Response to Submissions

State Significant Development Application (SSD 7564) Proposed Warehouse/Distribution and Industrial Facility

Lot 2, Horsley Drive Business Park (Lots 23 (part), 24 (part), 25, 28B, 30, 30A, 30B, 32 & 32A in DP 13961; Lots 1-5 in DP 1098128; Lot 100 in DP 879680; Lot 1 in DP 1036933; Part Lot 10 in DP 879209; and Lot C in DP 103755)

01 SEMI-TRAILER TURNING DIAGRAM 01
1:500 @ B1

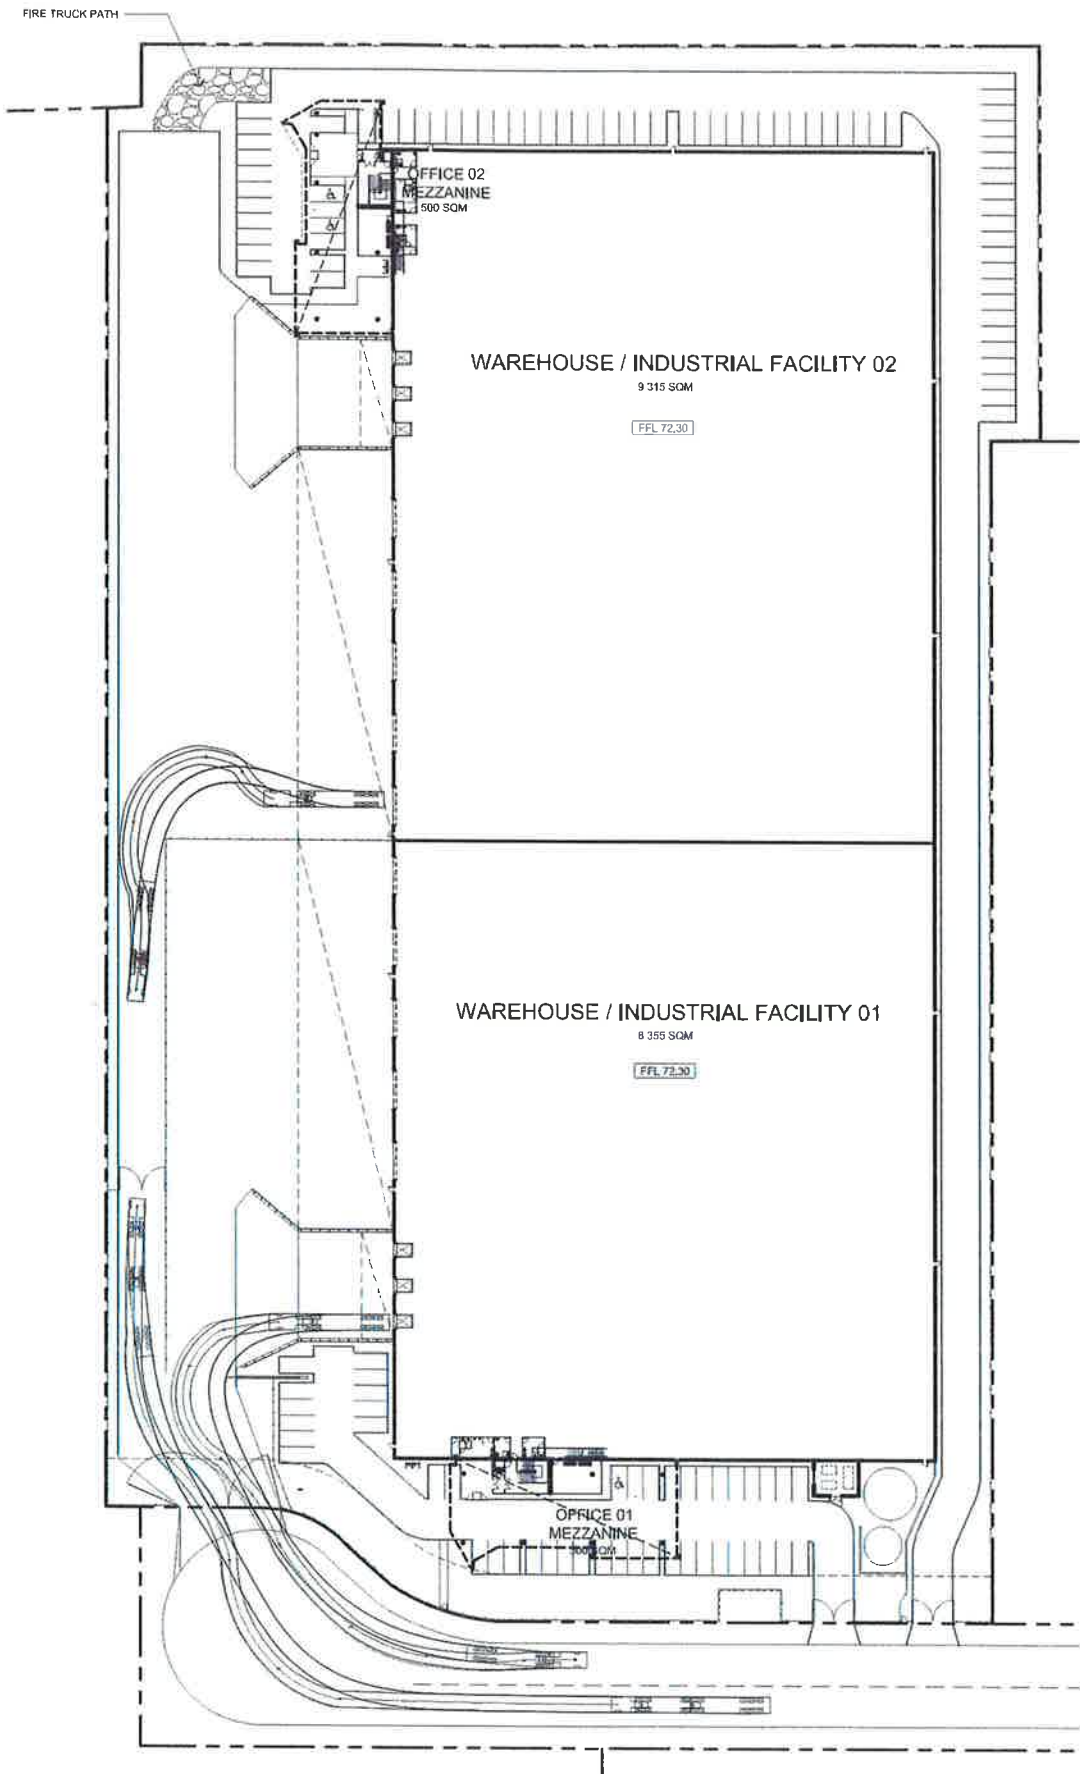
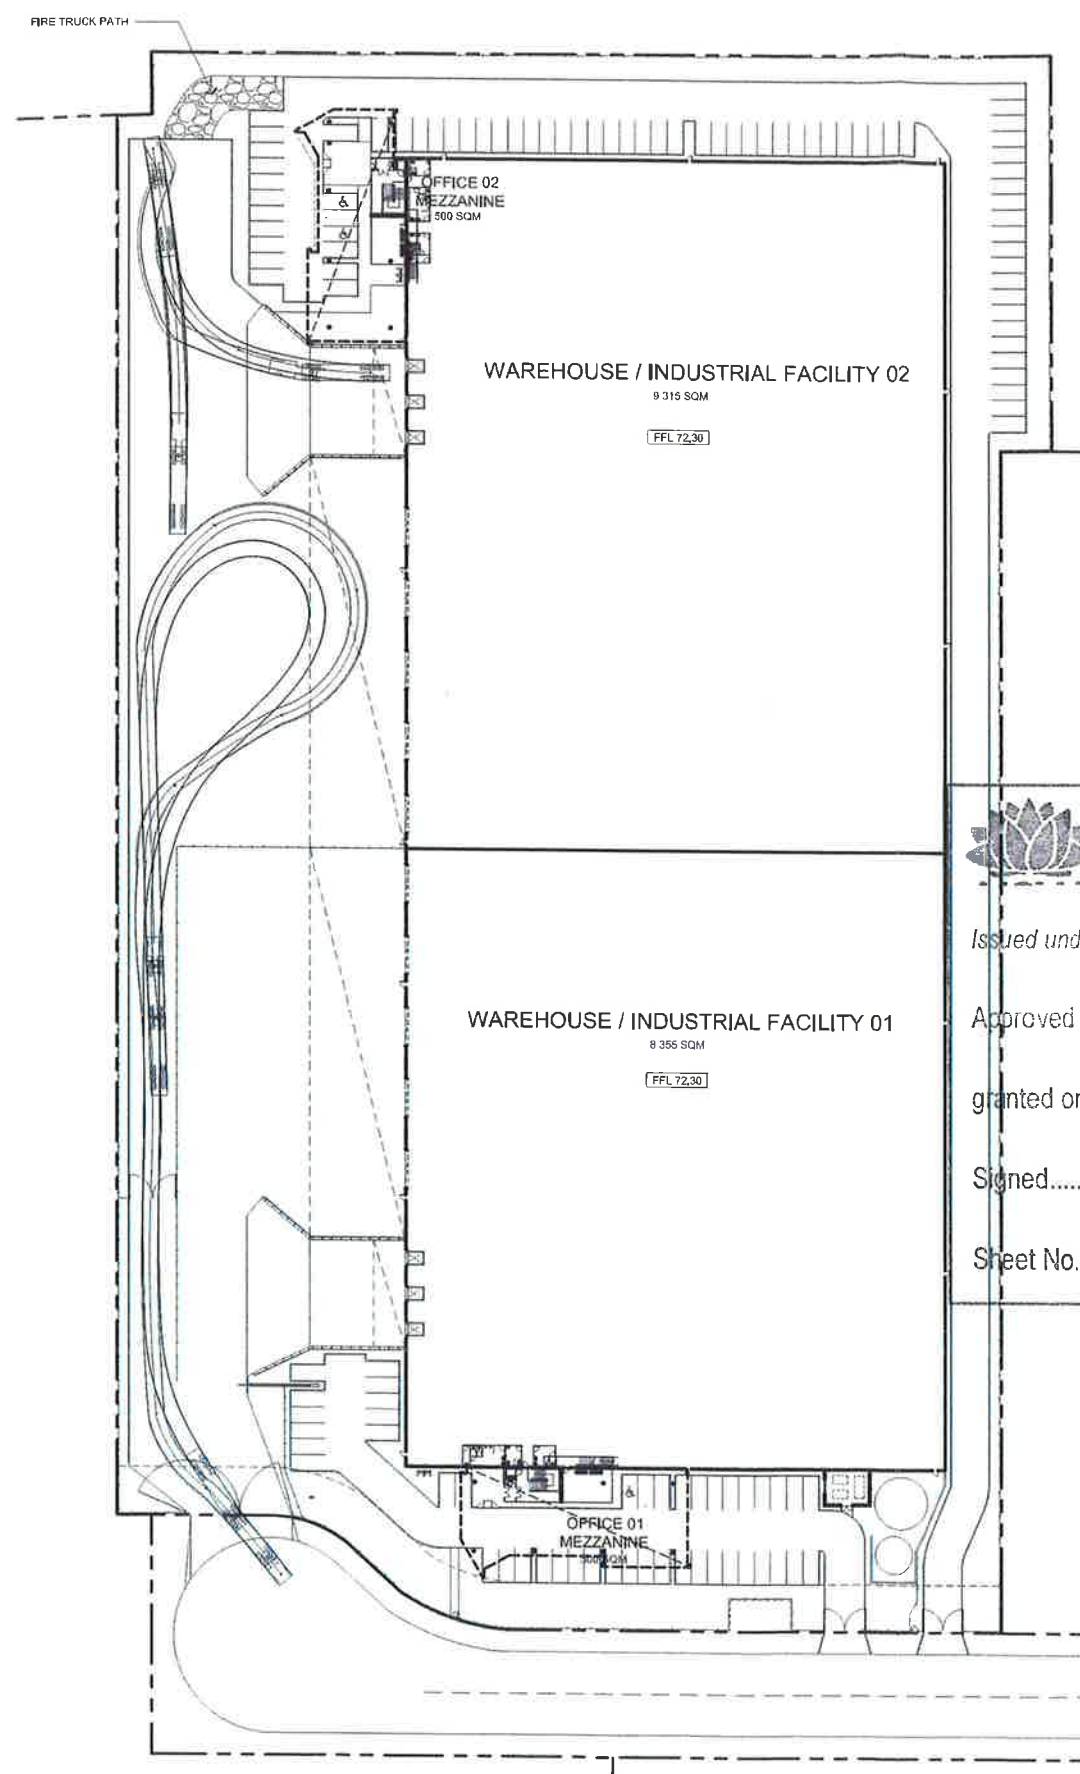
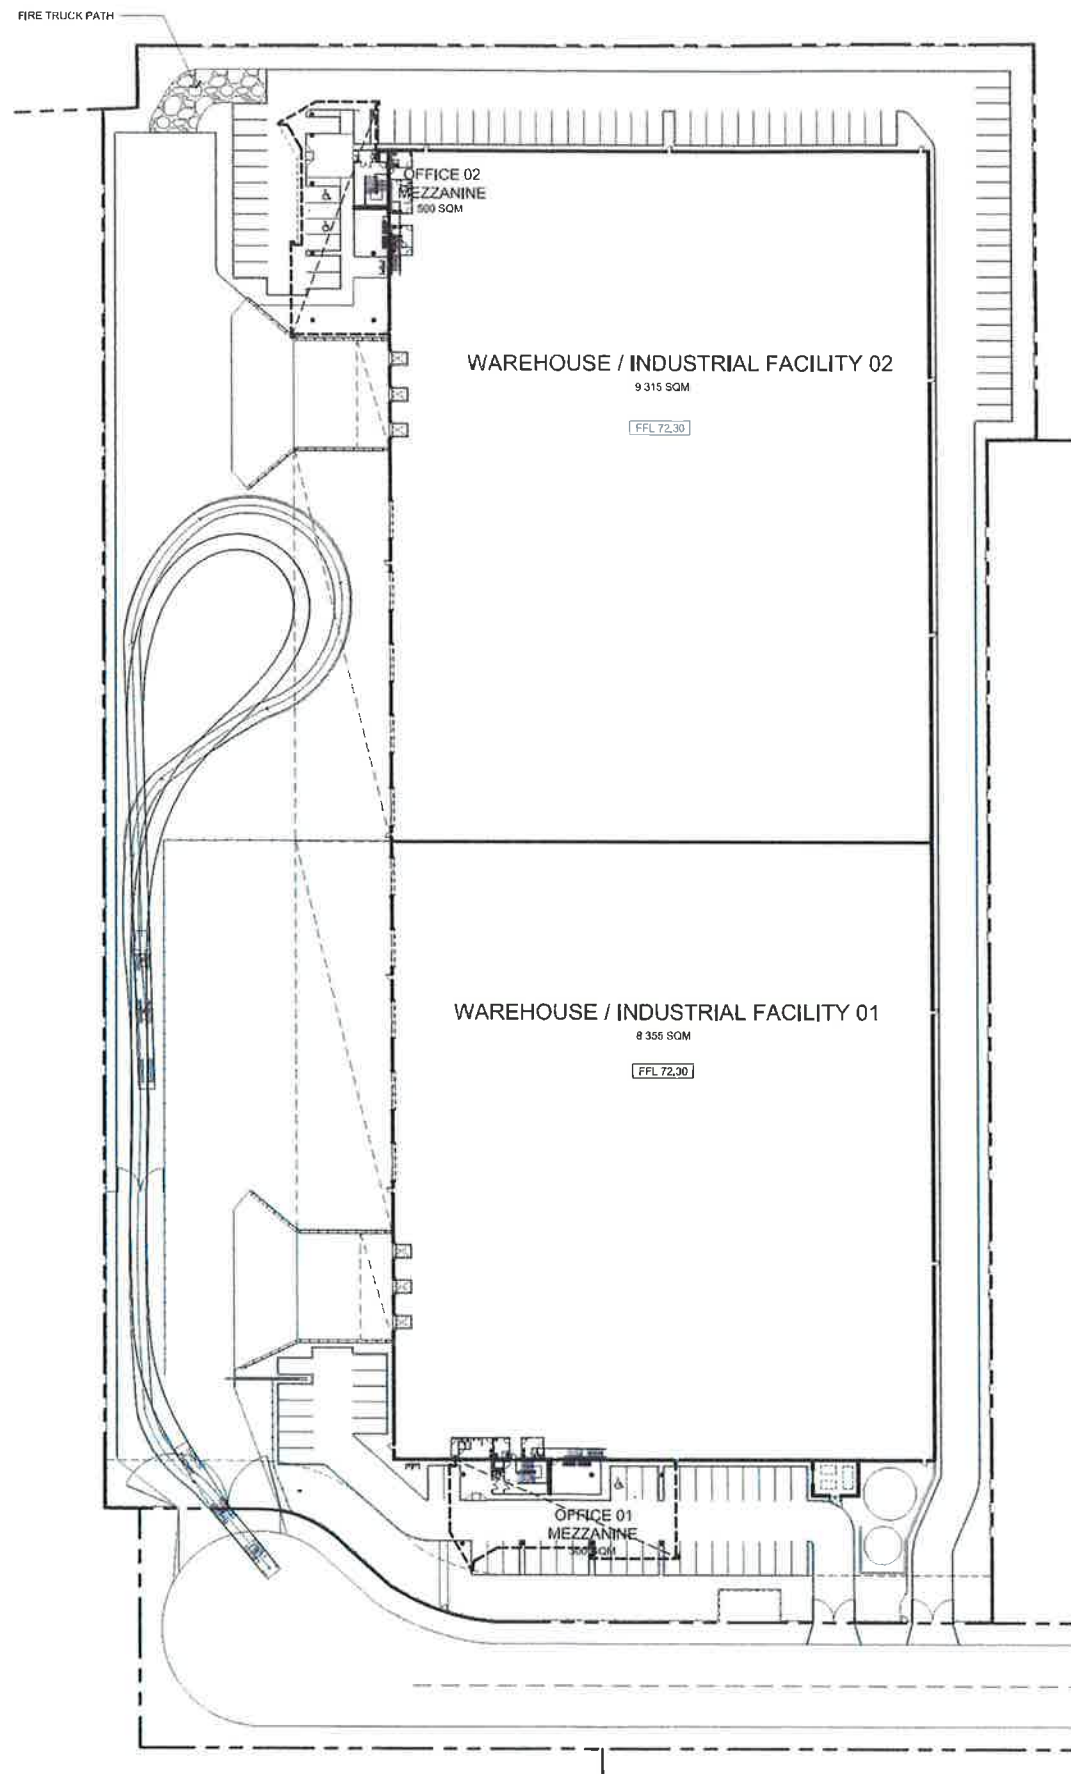
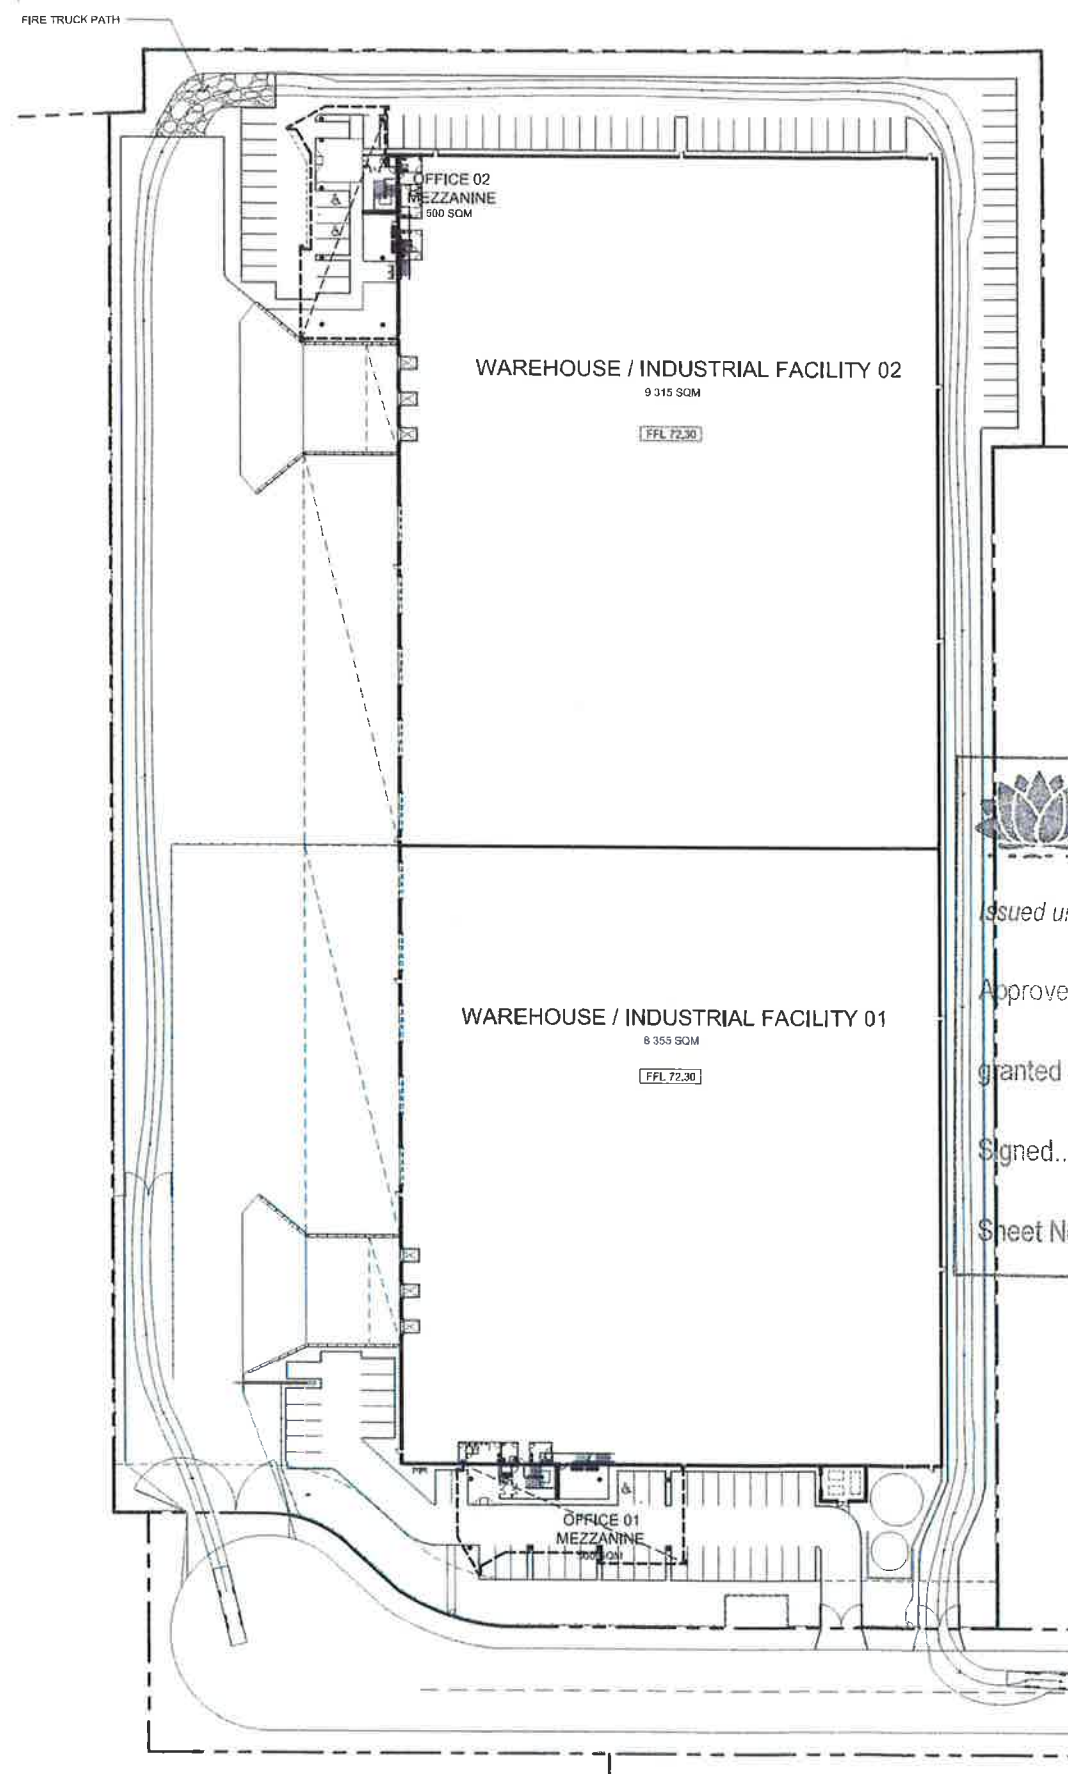
8. Transport for NSW	
a) Heavy Vehicle Access <i>The swept paths of heavy vehicles shown in the figures for the Traffic Assessment Letter Report require clarification. The swept path of B-doubles has been adopted for the access and some internal movements. However, the swept path of 19m semitrailers was used for the movements at the loading docks. Details of any coupling/de-coupling areas should also be identified and shown on the plans.</i> <i>Given the proximity of the site to the State Road network, subject to future government policy on HPV (High Productivity Vehicle) routes, the proposed development may be able to take advantage of the productivity benefits that High Productivity Vehicles offer. Therefore, it suggested a PBS Level 2B (i.e. up to 30m in length) vehicle turning path be considered in the design of the site access and internal circulation road to allow for future upgrades to accommodate these</i>	Road Delay Solutions have prepared an addendum statement (Appendix 8) in response to the Transport for NSW queries which confirms: <i>a) The adopted design vehicle for the site is a B-Double which will not engage in decoupling but employ side loading in close proximity to the loading docks, as outlined in the Loading Dock Management Plan, accompanying the State Significant Development Application.</i> <i>b) The proximity of the industrial facility site to the State Road Network has been noted. However, it is not the intention of the occupier of the site to employ the use of High Productivity Vehicles (HPV) but rather B-Doubles on a daily basis. Therefore, a Level 2B PBS Vehicle turning path is inappropriate for the site.</i> The use of Copland Close as a B-Double Route will be subject to a B-Double application being made to Fairfield City Council. This will be submitted upon dedication of the road to Fairfield City Council, as per the subdivision approval

<i>vehicles in the future. TfNSW requests that the swept path of maximum size of heavy vehicles that are envisaged to access the site be adopted for the design of the site access and internal area including the loading dock area to ensure sufficient space exists on the hardstand apron. It is also requested that routes of heavy vehicles between the site and the State Road network should also be identified and swept path analysis undertaken where required (e.g. left turn from Cowpasture Road south approach into Copland Close) to the satisfaction Council and Roads and Maritime Services.</i> <i>It is noted that B-double access along Copland Close to the site would be subject to approval of Council (possibly through the local traffic committee process) and the National Heavy Vehicle Regulator.</i>	which formed part of SSD 5169.
